Harnett County Government Complex
307 W. Cornelius Harnett Boulevard
Lillington, NC 27546

RE: Harnett County Land Use Existing Tank Application # 17-5-41545

Operation Permit

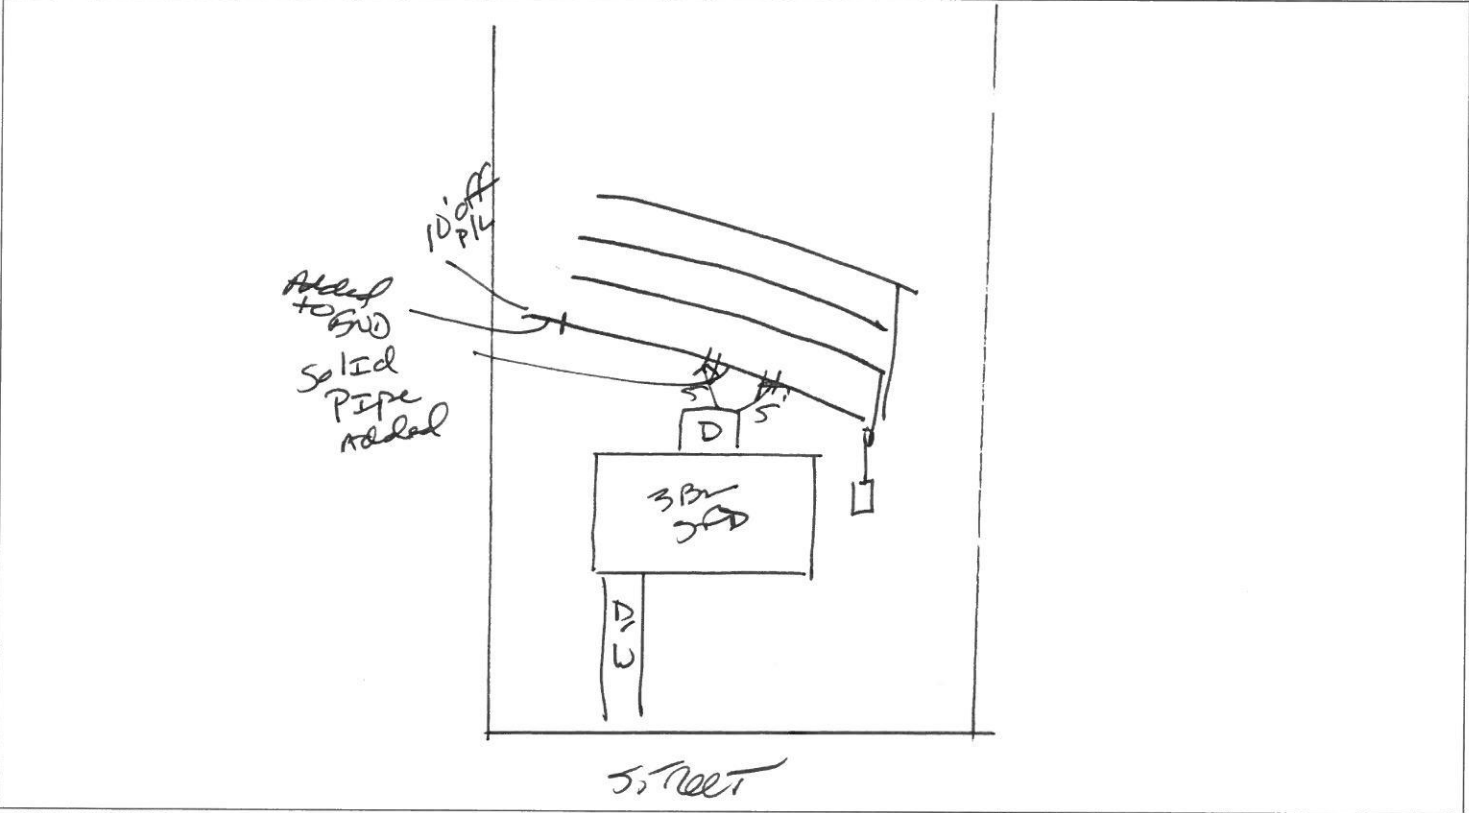
X 15A NCAC 18A.1950 {10} - Any building to be 5' from septic tank and/or from drain line. Deck expansion built two feet off existing septic system.

Contact a septic installer to hard pipe to create a five feet setback and re-add to system to end of the septic line. Call me to discuss further in detail. If you should have any questions or concerns, I can be contacted Monday through Friday from 8am – 9am at 910-893-7547.
